From: Mark Burchett 
Sent: 08 May 2019 19:29
To: Charlotte Easton
Cc: Planning
Subject: Re: 8 Solent Close, Littlehampton - LU/96/19/CLP

I write to your regarding the application you have submitted for a certificate of lawfulness for a proposed single storey rear extension at 8 Solent Close, Littlehampton.

Drawing Title
**Existing and Proposed
Plans, Elevations & Sections**

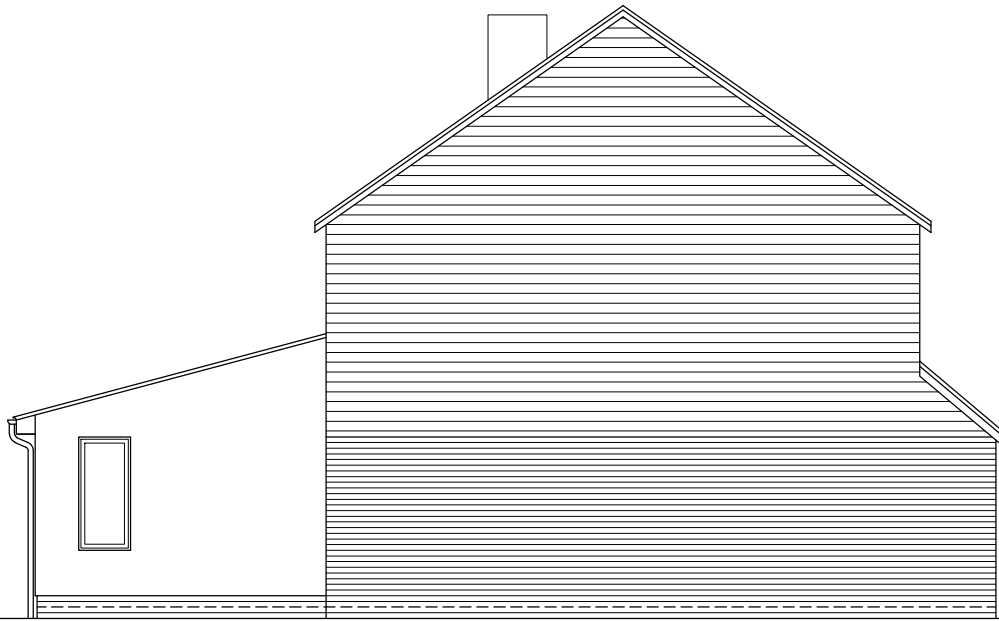
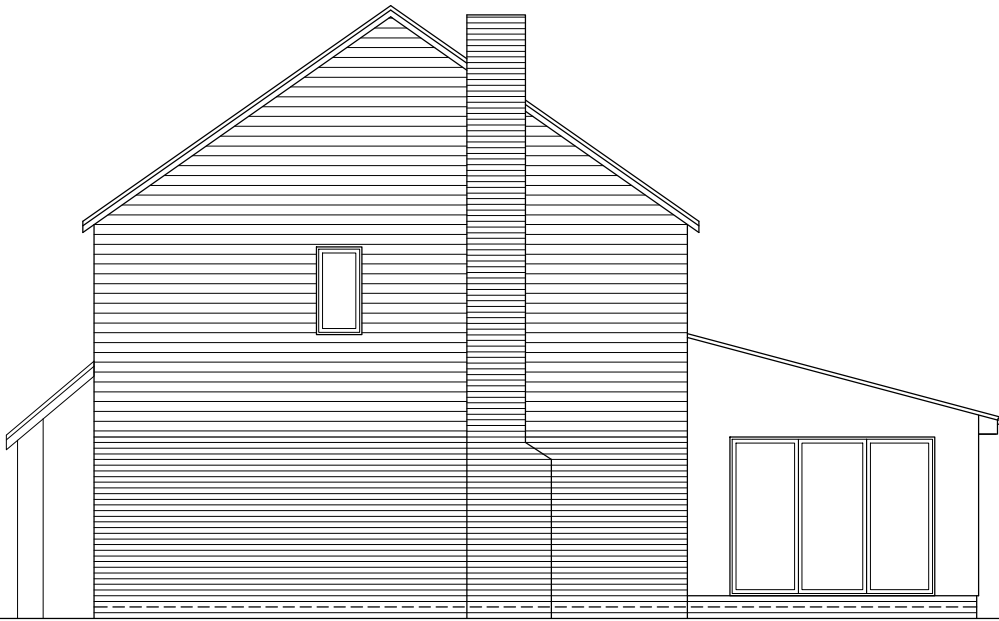
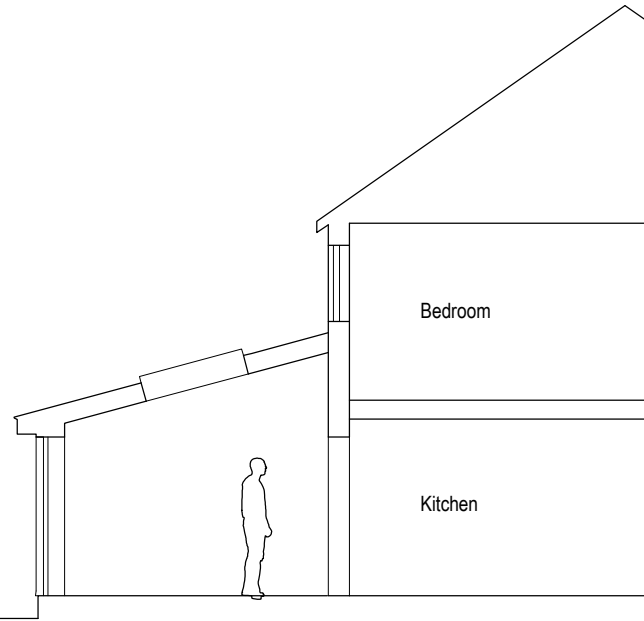
I am in the process of writing the report for your application and need to confirm if the proposed materials to be used in any exterior works for the proposed extension will be of a similar appearance to those used in the construction of the exterior of the existing dwelling?

The proposed materials of the proposed rear extension are as follows:

Roof - Fibre cement slates which also work well with the shallow pitch <https://www.eternit.co.uk/en/products/slates>

Walls - Smooth white render and to the brickwork at low level a blue/grey engineering brick.

Window/doors - Grey aluminium slim profile.
